DEVIATION REQUEST AND DECISION FORM

| Project Name : | Crossroads North |

The requested deviation is for left turn lane length criteria (ECM Standard 2.3.7.E.2 & 3)

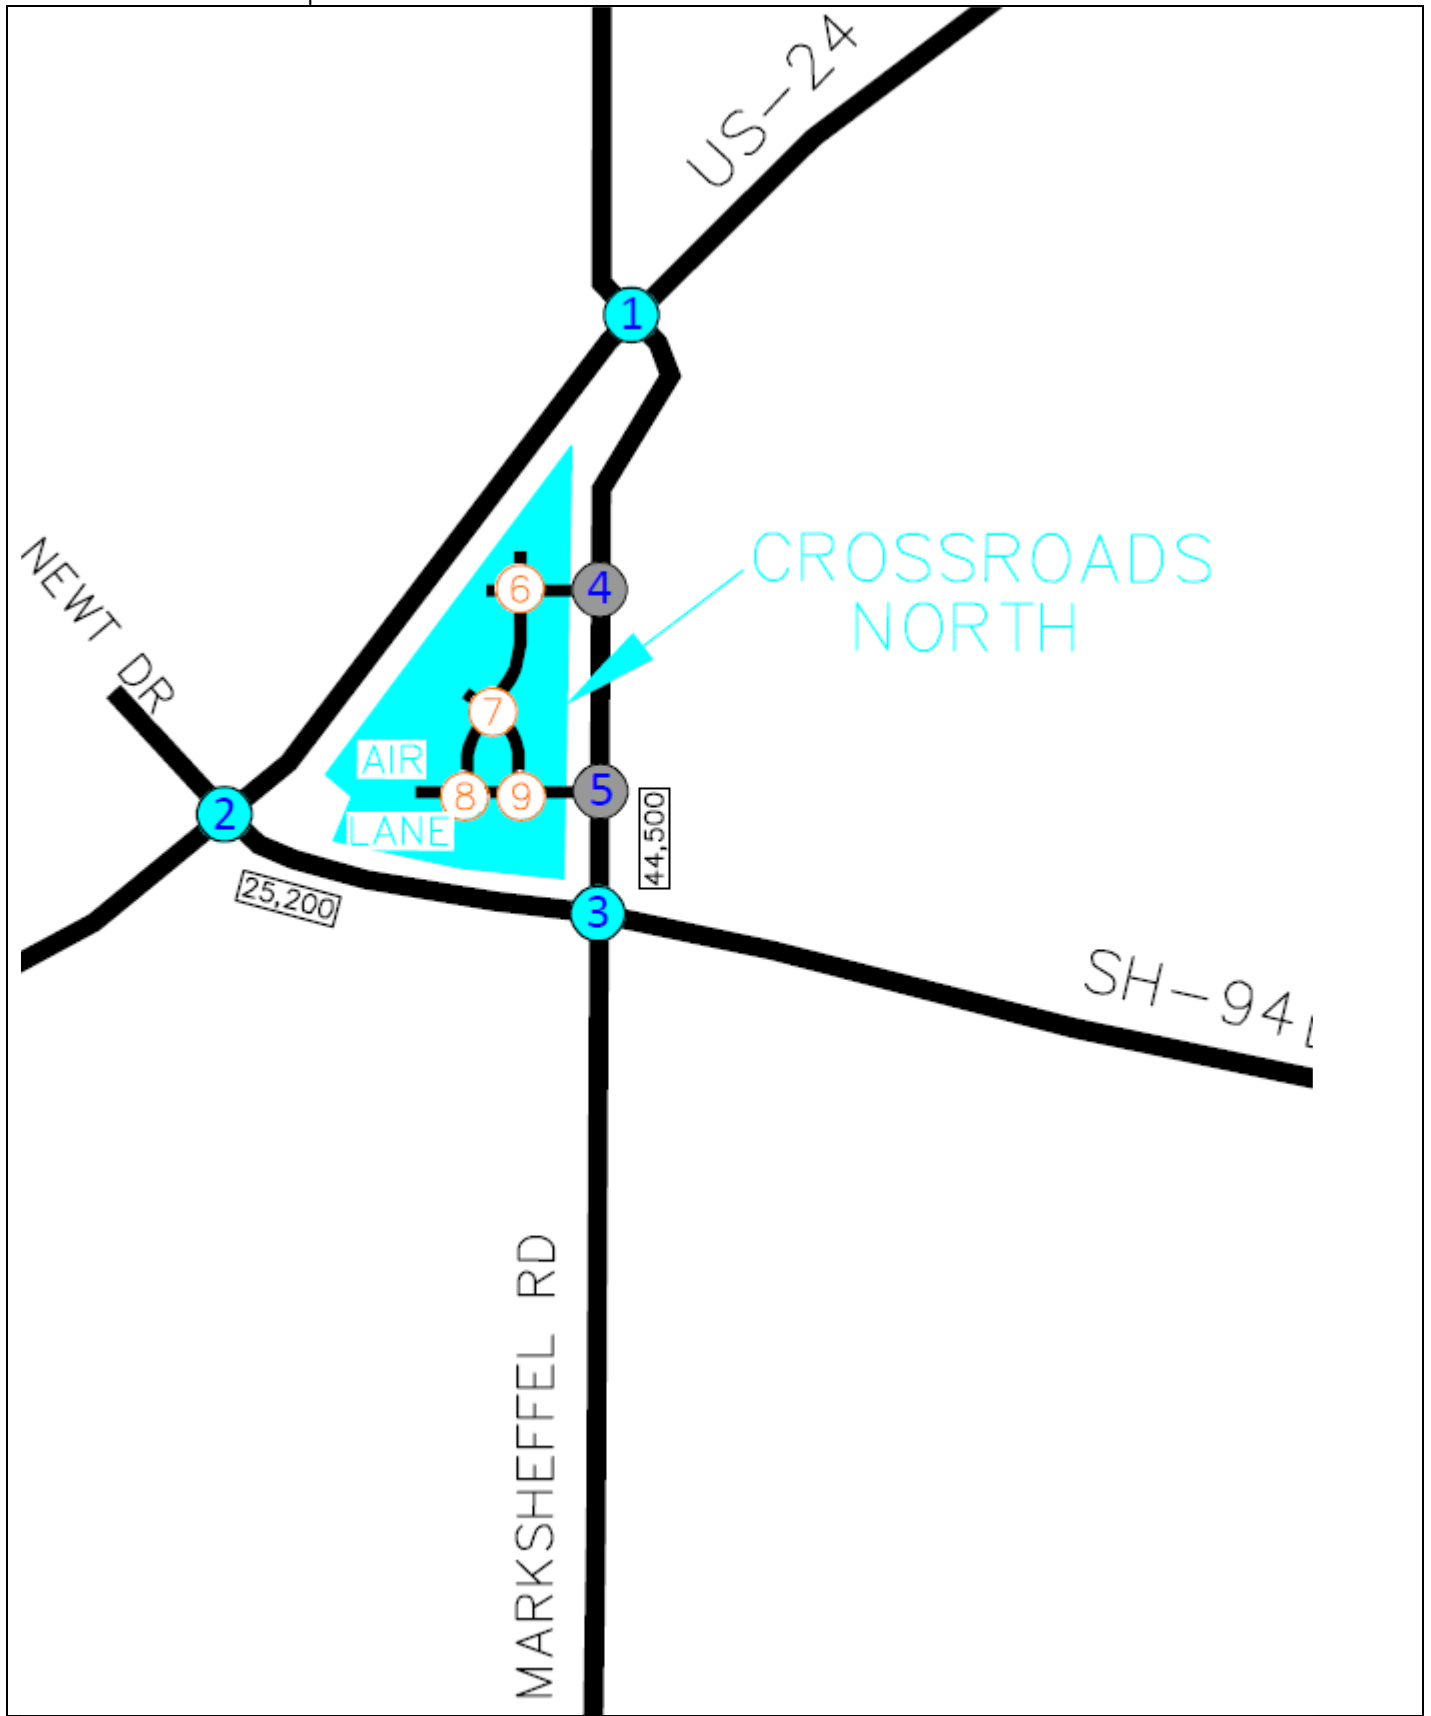
Deviation Request to be withdrawn.

After the last submittal review (Review #2) Marksheffel Road was deeded to the City of Colorado Springs for ownership/maintenance. Coordinate with City of Colorado Springs for their requirements.
